From: Aisling Mooney <Aisling.Mooney@arup.com>
Sent: 2019-04-18 09:37
To: Garvey, Kasia; Connolly, Sharon
Cc: Mary Hurley; Eileen McCarthy; 'Fintan O'Meara'; Sean Devaney
Subject: Gort na Bro Development Comments

Arup have reviewed the proposed planning application by Atkins in the context of the interaction with the proposed N6 Galway City Ring Road (GCRR) scheme which is currently before An Bord Pleanála. The Gateway Urban Village, Knocknacarra development and the N6 GCRR scheme overlap in the area of the proposed realigned entrance to the Galway Retail Park. Both schemes propose the realignment of the existing entrance to Galway Retail Park from its current location as a fifth arm of the Gort na Bró Roundabout on the Western Distributor Road to a new location to the north onto Gort na Bró Road. Galway County Council do not object to the proposed Gateway Urban Village, Knocknacarra development subject to it including for the provision of the plan layout and vertical layout of the proposed realigned entrance to Galway Retail Park as currently shown in the N6 GCRR planning application.

We have reviewed again with reference to the earthworks not being necessary as part of the prop

Drawing file: Traffic and Roads / HT 0102 - General Arrangement.pdf

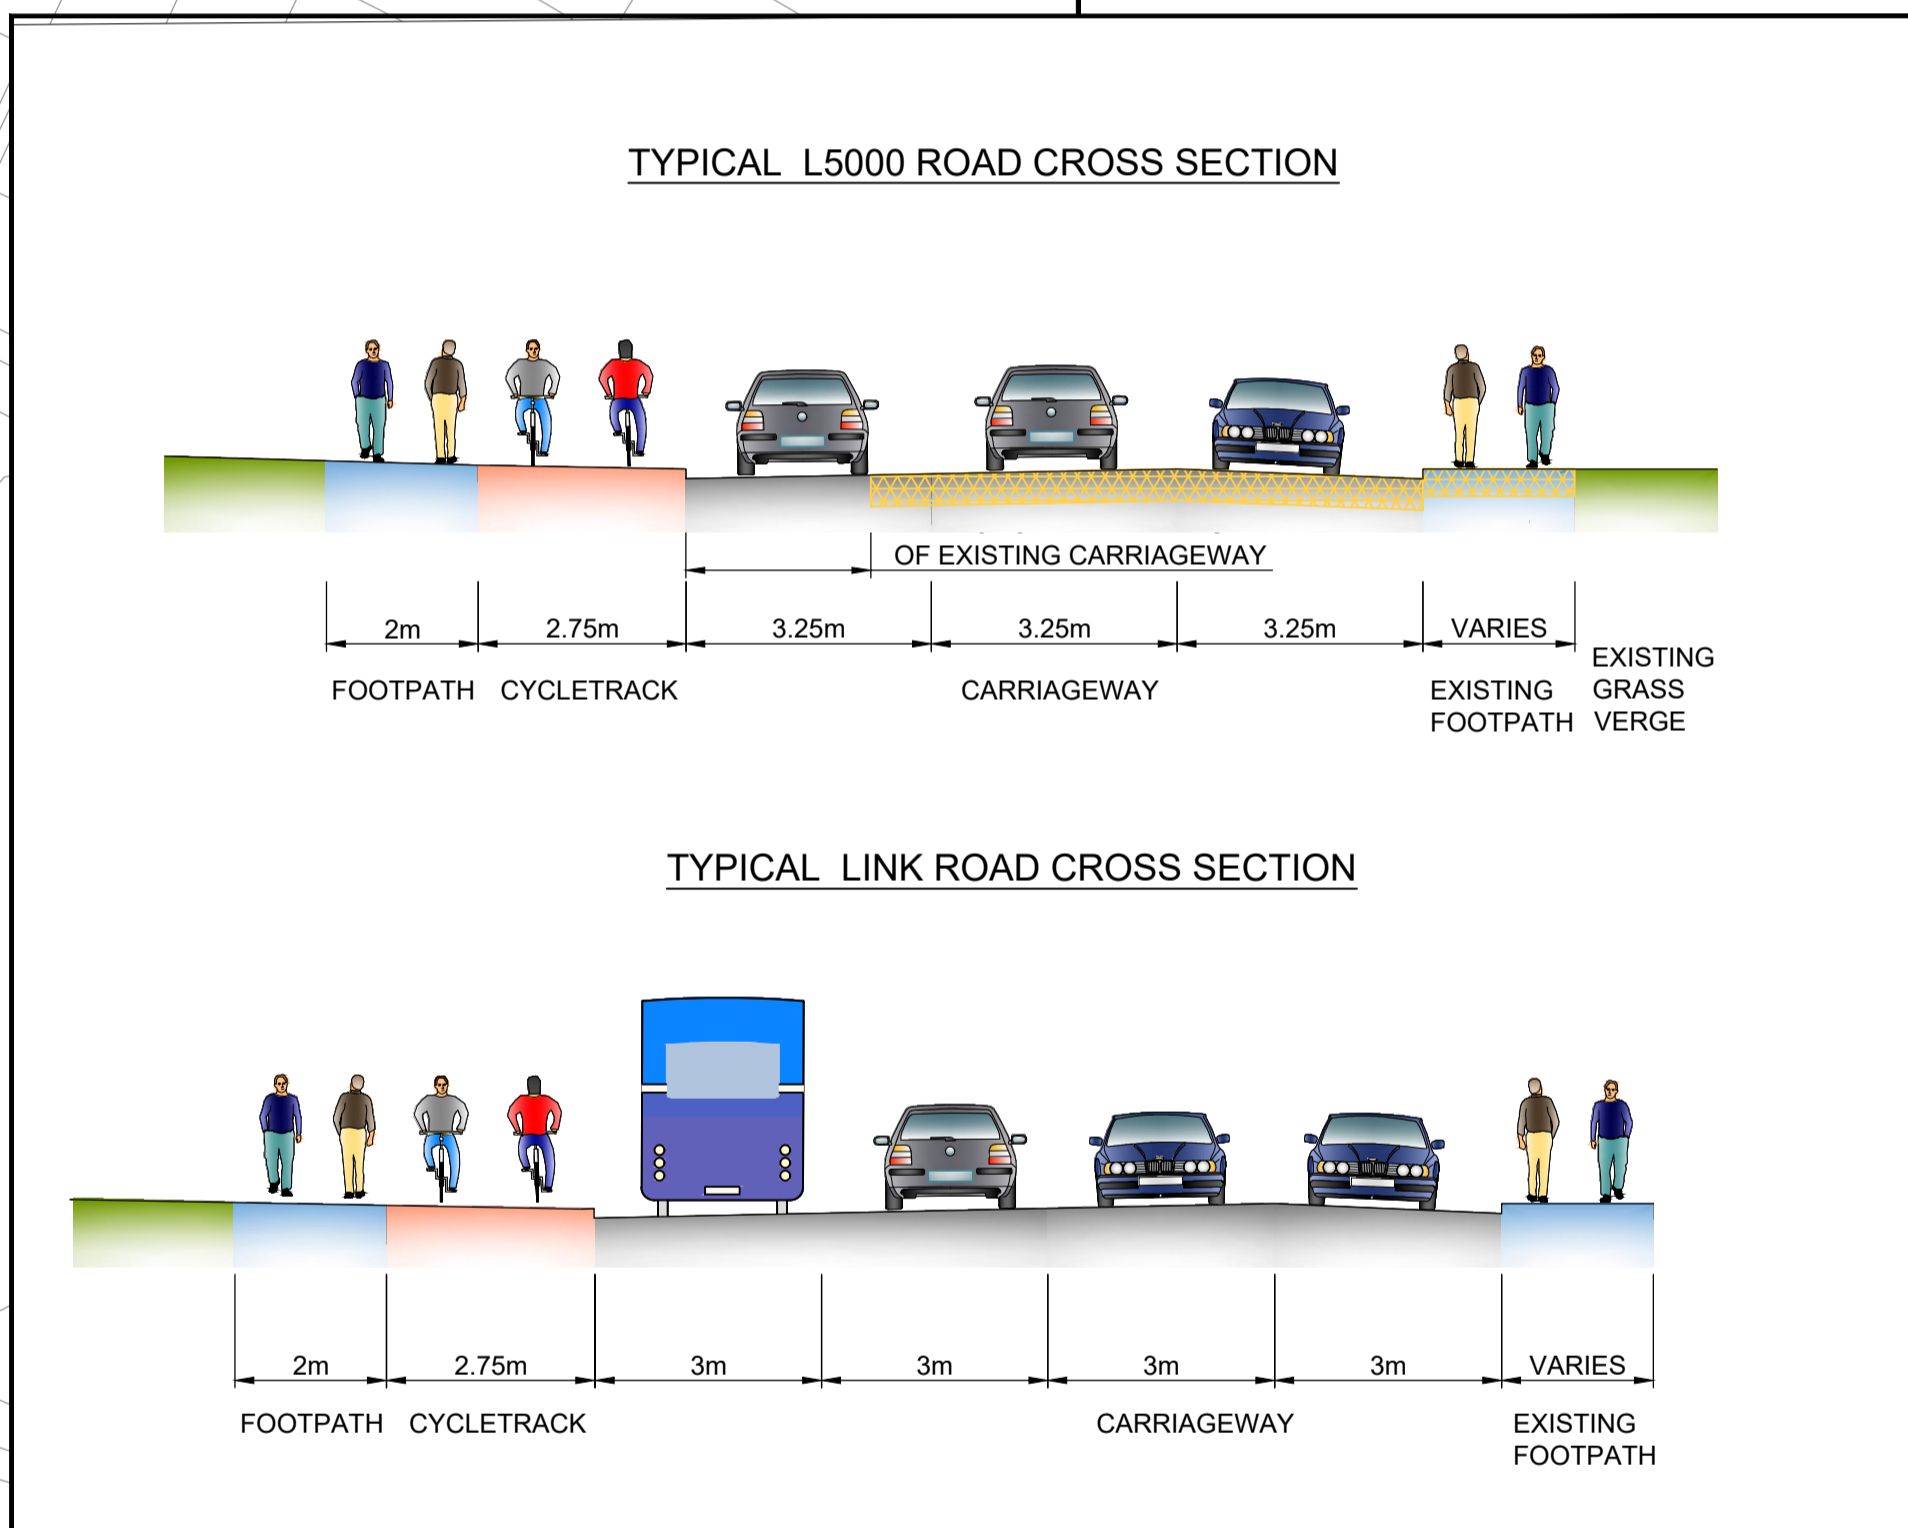
Could you also supply the red line boundary for your proposed development which will be submitted as part of the planning application? We note that your proposed development could potentially be developed before a planning decision is made with respect to the proposed N6 GCRR. If this were to happen, the widening of the Gort na Bró Road to the north proposed as part of your development would encroach on private land which will not be in ownership of the council unless the Motorway Scheme is approved by An Bord Pleanála.

We have reviewed your proposed development with respect to the design for the N6 GCRR and have found a conflict on the northern plot. The proposed design for your development is within the red line boundary of the N6G CRR and encroaches on the proposed earthworks on that side which leaves no working room for

said earthworks. We would recommend that the northern plot be offset so it is not within the red line boundary. (See snip of conflict below)
